Memorandum

Project Name: TSP129181 Christopher King

Permit Address 265 Hester Pl Cameron NC 28326

PV LAYOUT  
**PV 3**

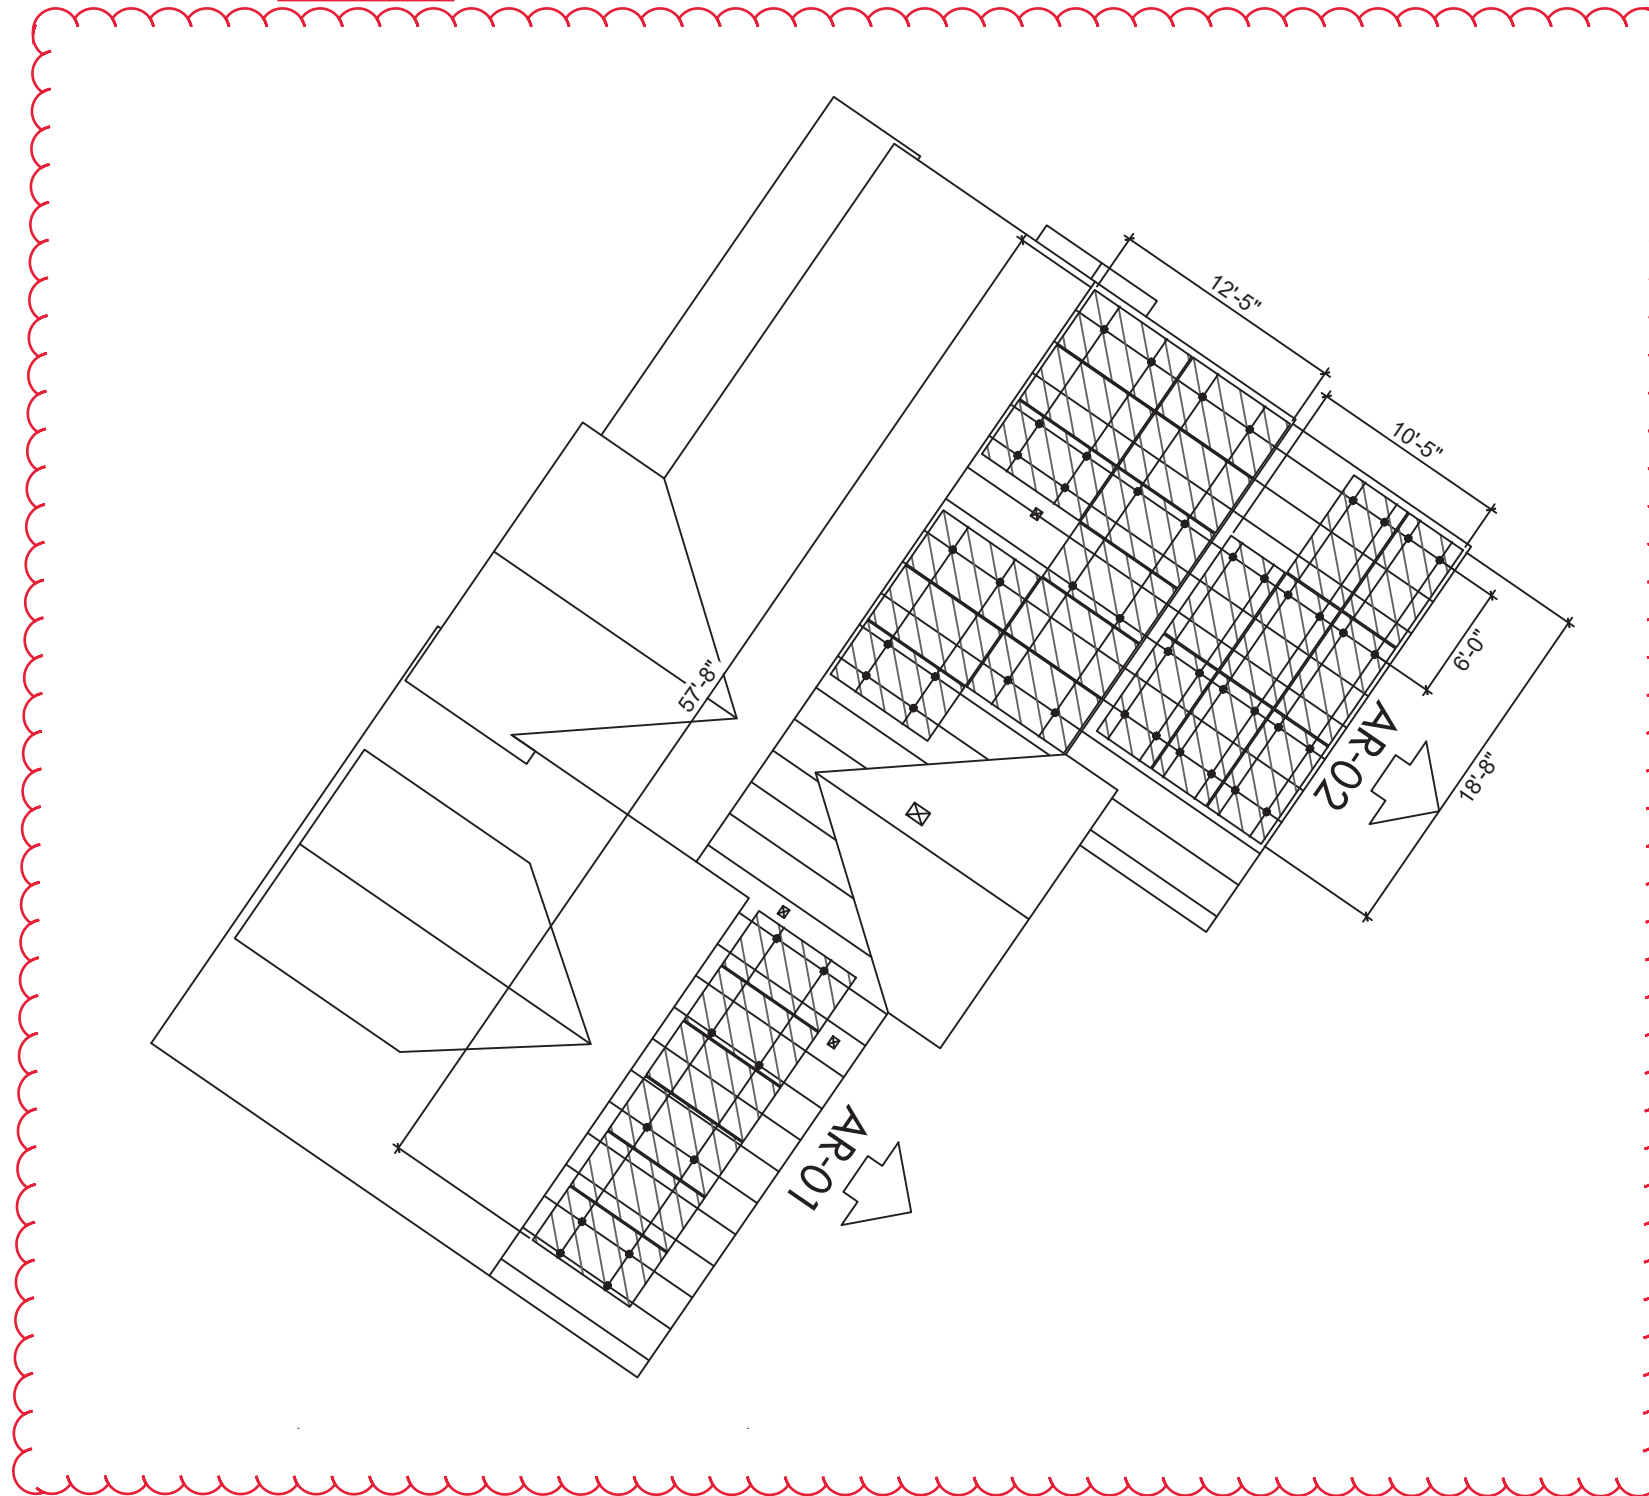
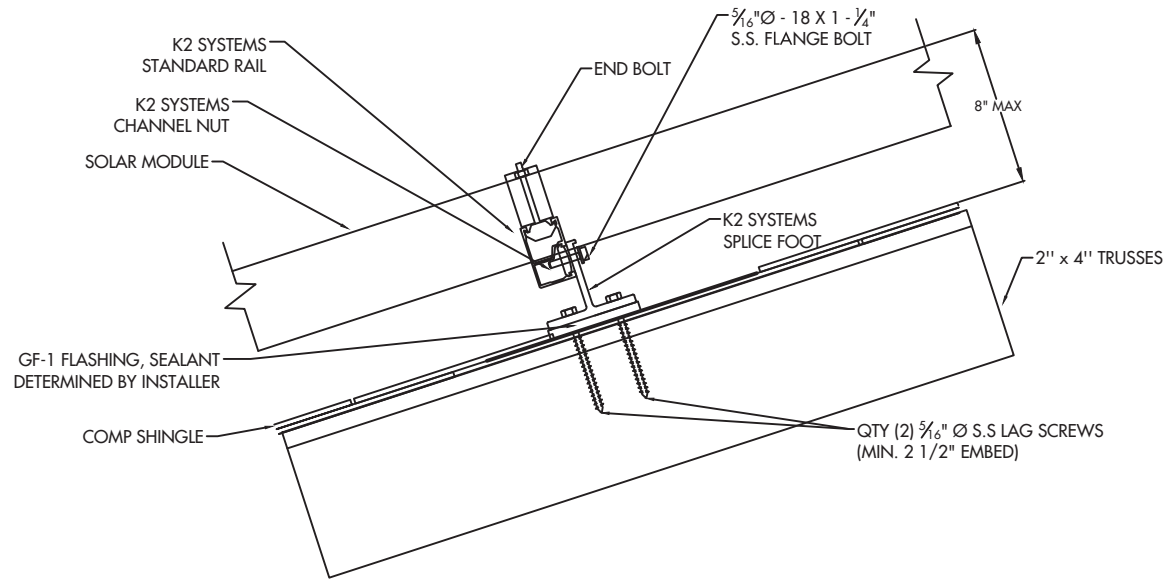
- Changed the optimizers to P340s, and matched installed layout
